From: Joe Russell-Wells
Sent: 13 May 2014 17:19
To: Neil Crowther
Subject: Land south of Littlehampton Academy - LU/51/14

Joe Russell-Wells | Environmental Services and Emergency Planning Manager, Greenspace and Emergency Planning, Arun District Council | Location: Bognor Regis Town Hall, Clarence Road, Bognor Regis, PO21 1LD

DESIGN PROPOSALS - LAYOUT

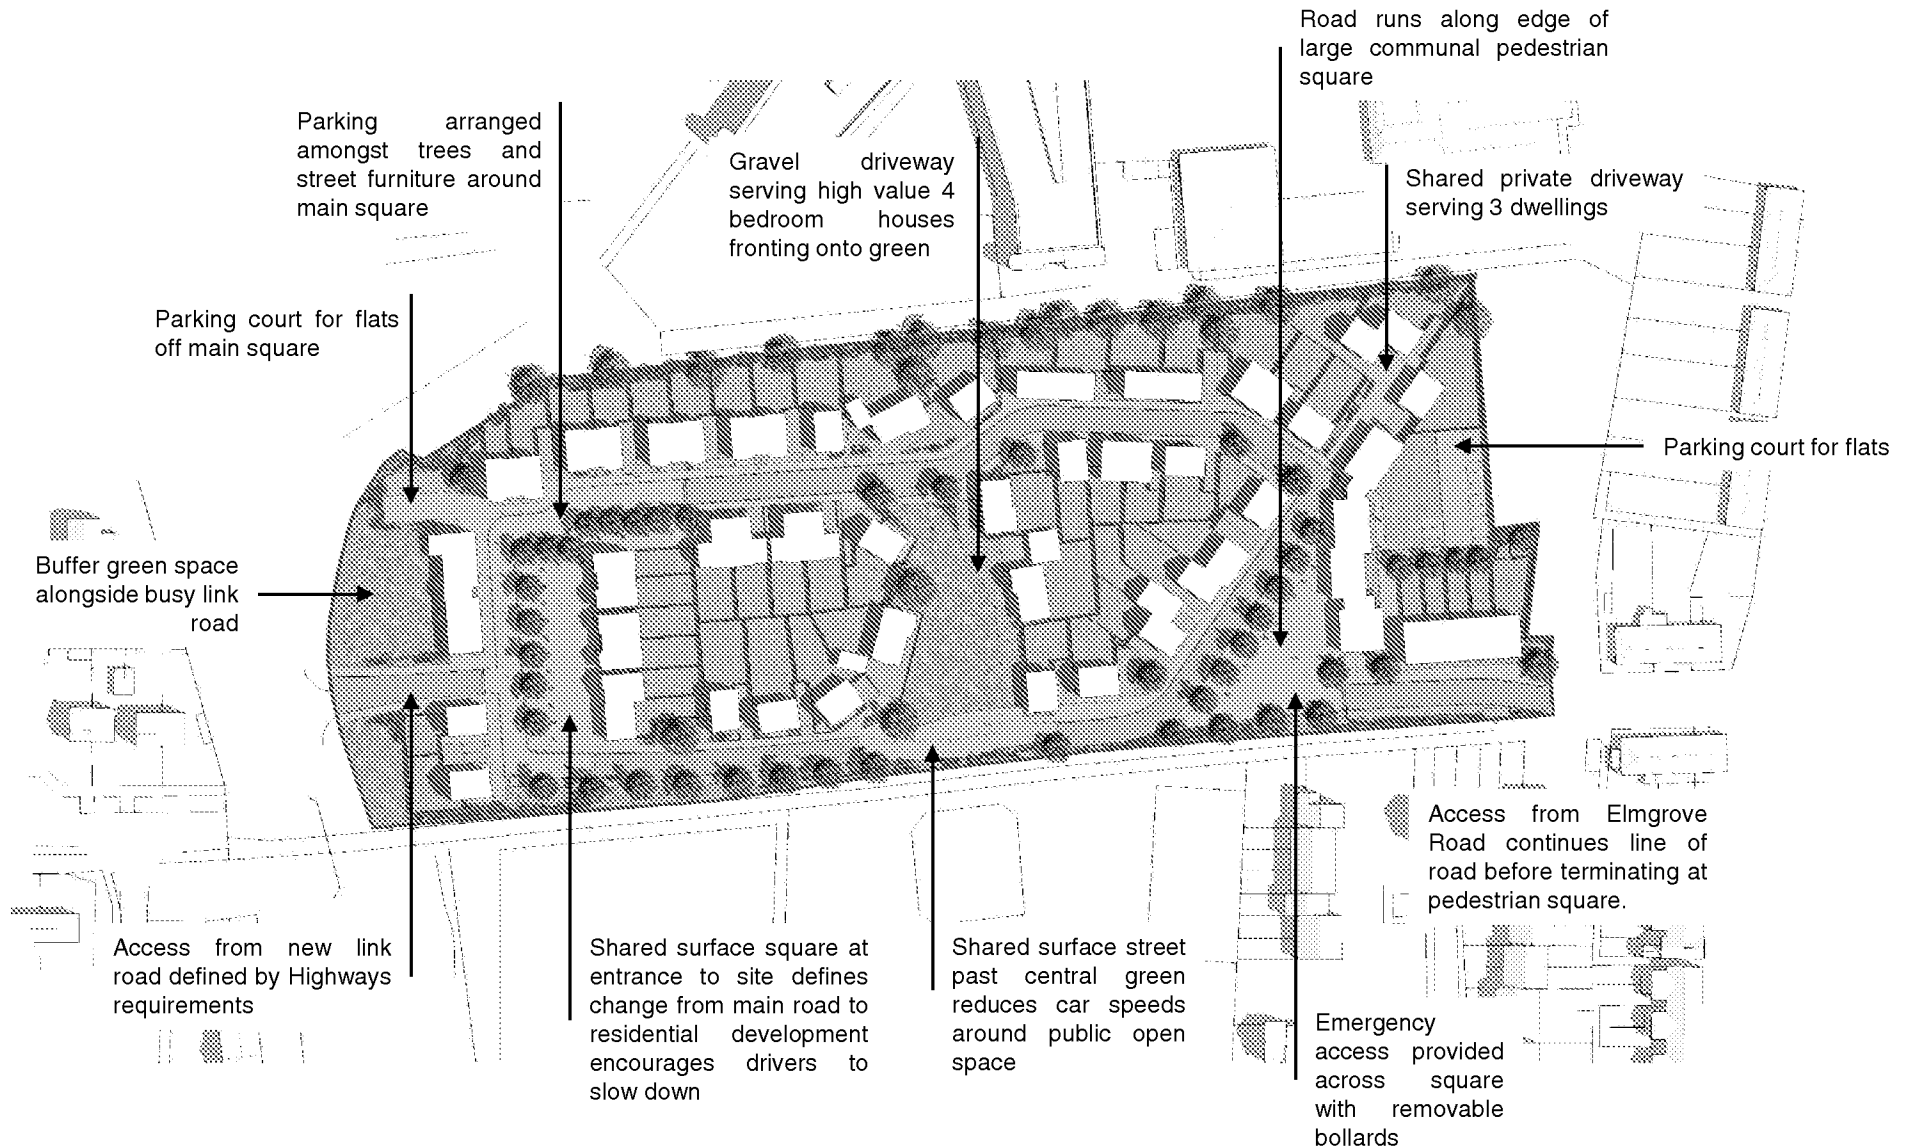
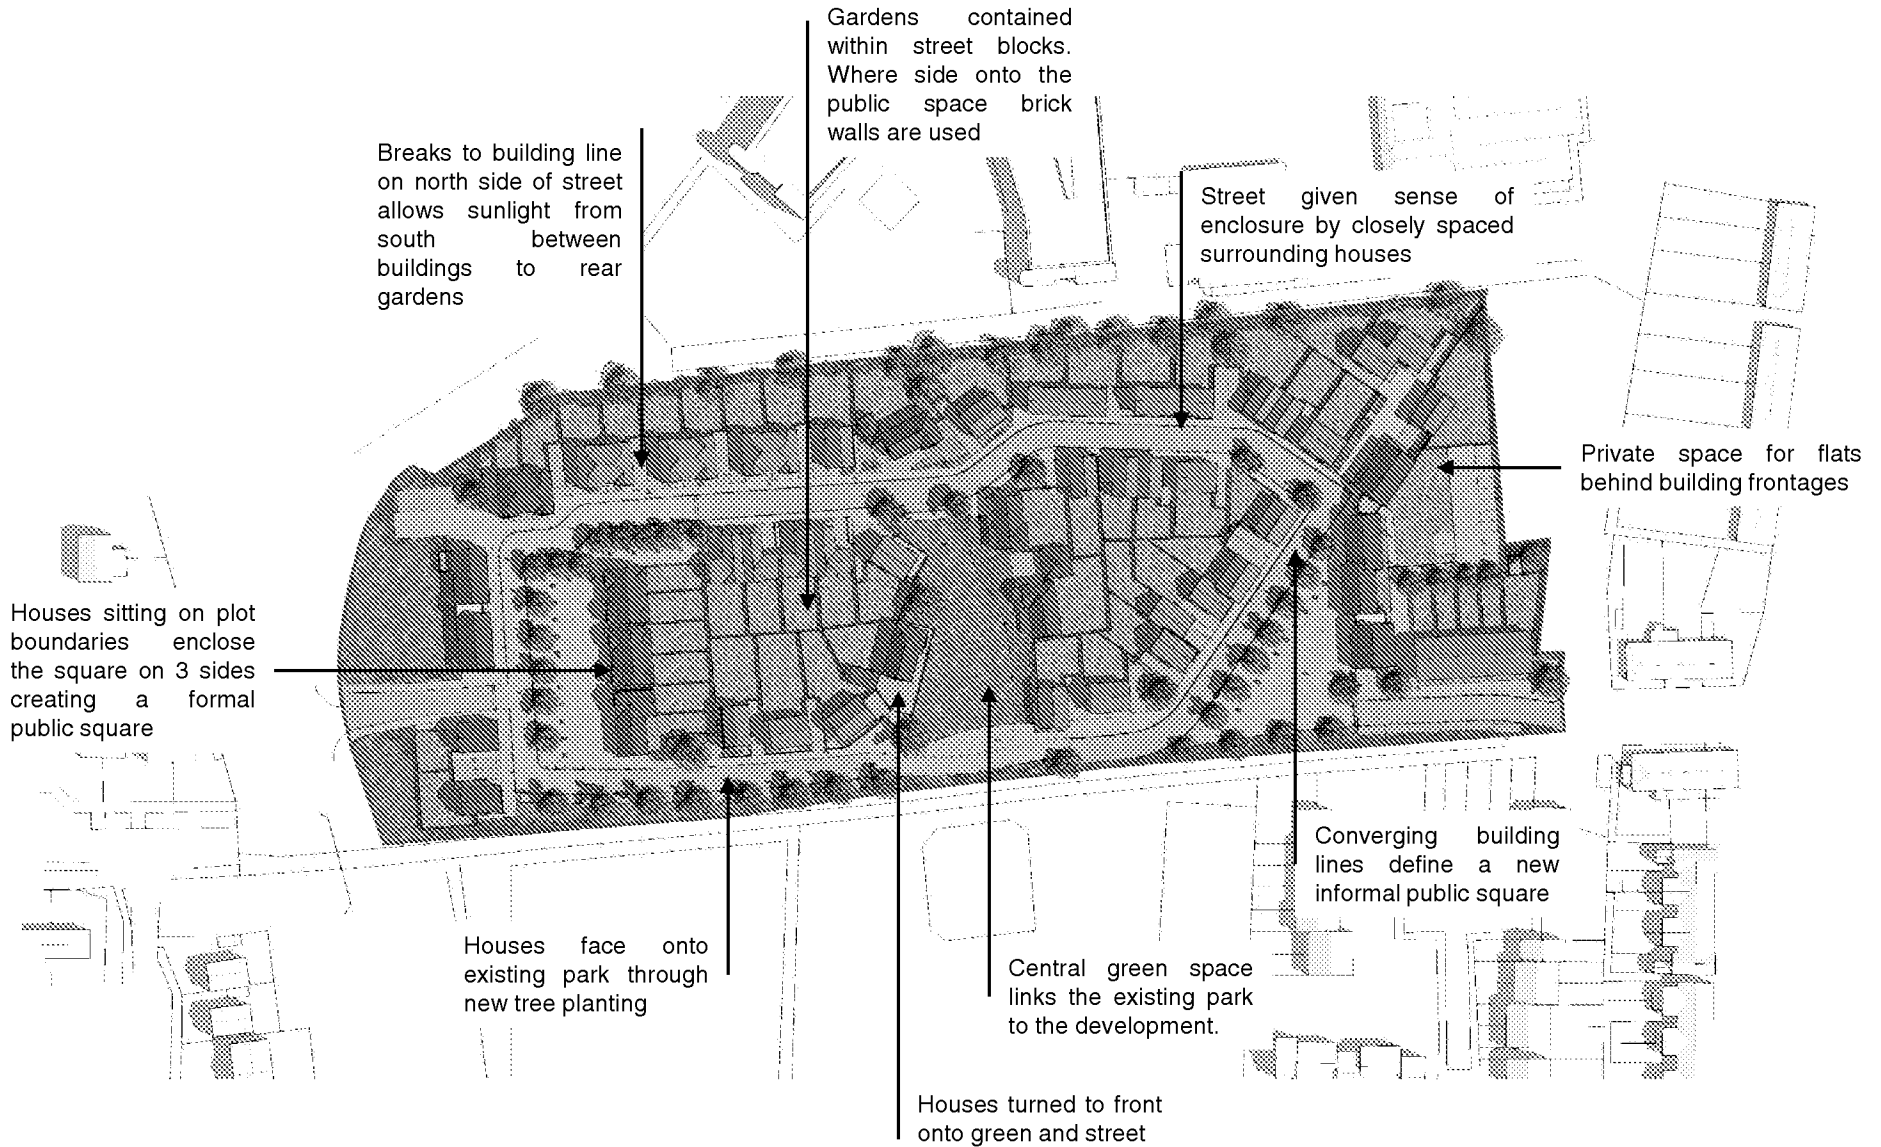
A development of this scale with the provision of 56 houses and 12 flats should be providing for an area of public open space of 0.3 ha in accordance with the Council's SPG. It is unclear as to the area of POS that would be delivered through these development proposals, until the amount of open space clearly identified on a plan is provided, it is guesswork to determine the open space provision, however on the basis of the proposed layout plan the it appears inadequate. The SUDS area adjacent to the new link road would be questionable as open space together with the paved squares. Together they provide a poor layout for the development in terms of open space provision.

There is neighbouring POS to the south of the development site it may therefore be appropriate for an off-site sum to be provided to enhance the existing provision together with good access links from the new development to the open space area. However until the proposed area of POS is clarified no further comment can be made.

In addition to the open space requirement there is the need for on-site provision of play area LEAP. Due to the close proximity of the nearby POS area it may be appropriate to have an off-site sum for improving the existing nearby play facilities – [REDACTED]
